KITTITAS COUNTY COMMUNITY DEVELOPMENT SERVICES

May 7, 2021

RE: Swiftwater Storage Conditional Use Application (CU-20-00006)

WLC PROPERTY HOLDINGS LLC
SITE PLAN

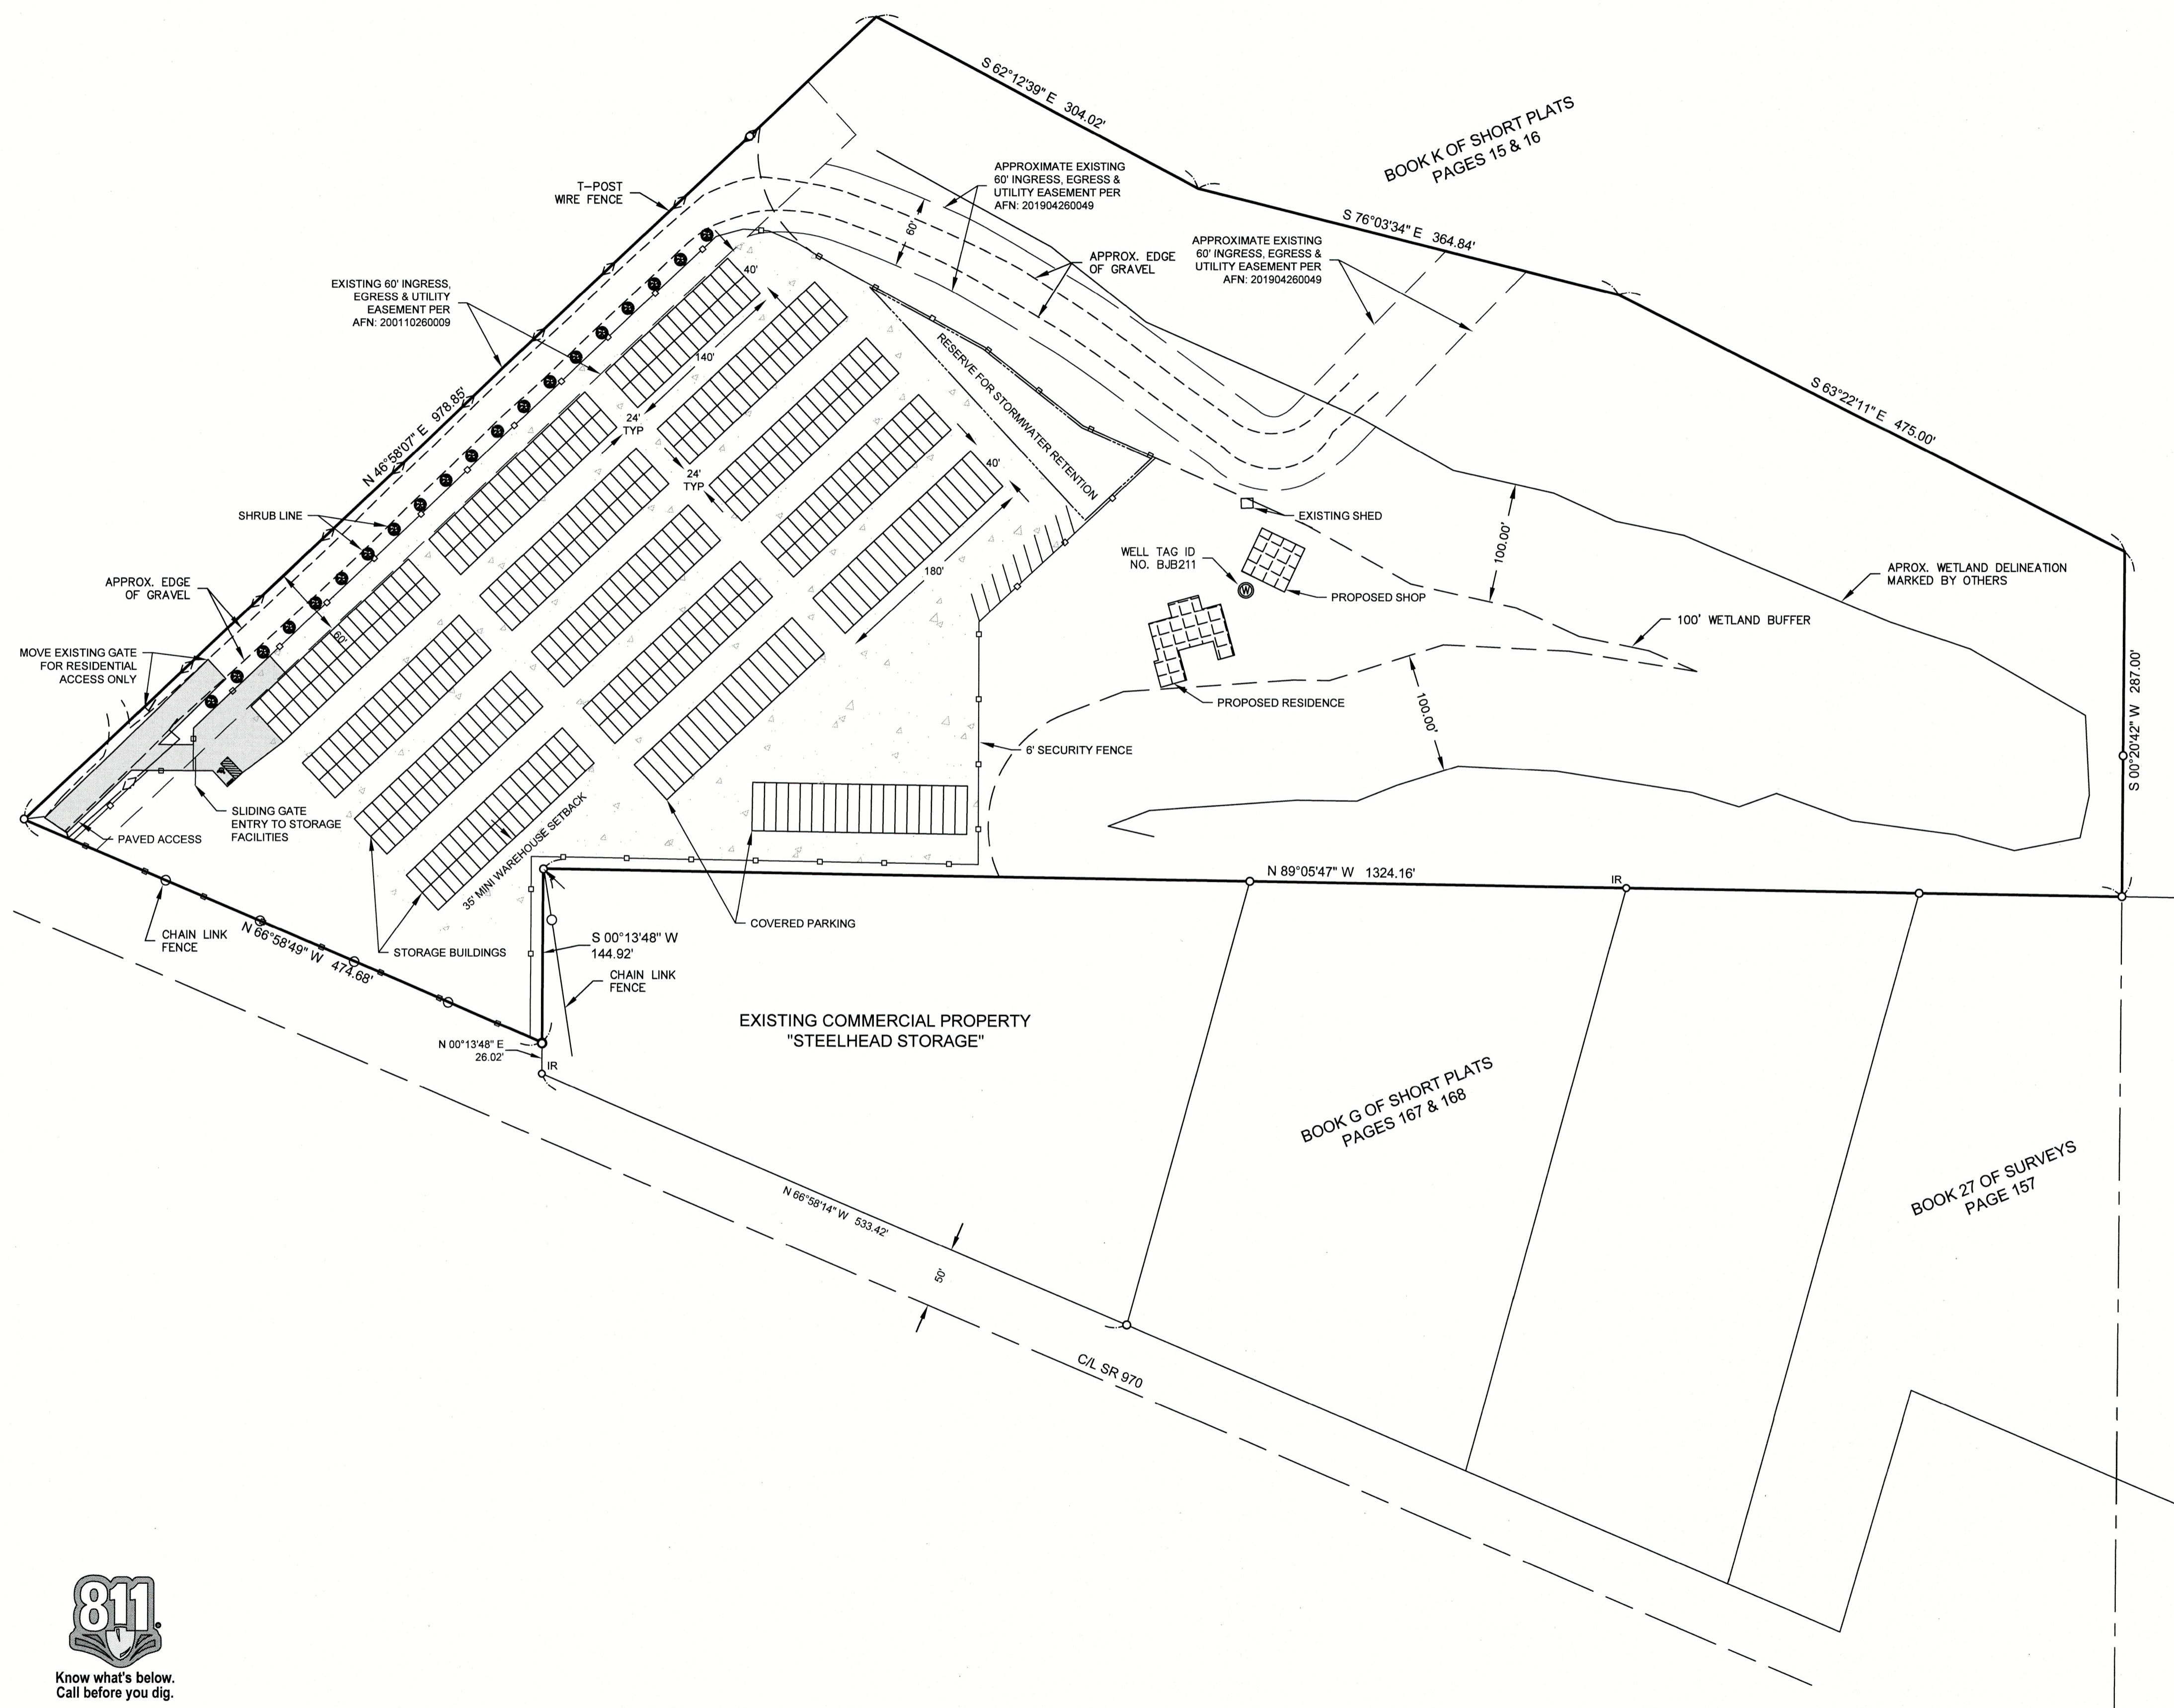
During a joint site visit conducted by Lori White of DOE, Josh Mitchell and myself, a few concerns were discussed. The defined wetlands based on the Sewall Wetland Consulting, Inc. report submitted for parcel #15445, lacked detailed information and an outlined boundary of the delineated wetland, no data sheets regarding the interior wetland, and did not address the man made pond in which was found to of had some fill being placed without consultation. During the site visit it was found that multiple spots had been cleared and campsites had been established within the northwestern wetland buffer.

1. A narrative from the consultant detailing how they determined the termination of the wetland boundary in the forested area and not further west.
2. A revegetation and monitoring plan for the wetland buffers that have been disturbed. Please ensure the plan includes native vegetation and adheres to Kittitas County noxious weed ordinances. Washington State Department of Ecology Wetland Mitigation in Washington State Part 2: Developing Mitigation Plans can be found [here](#).
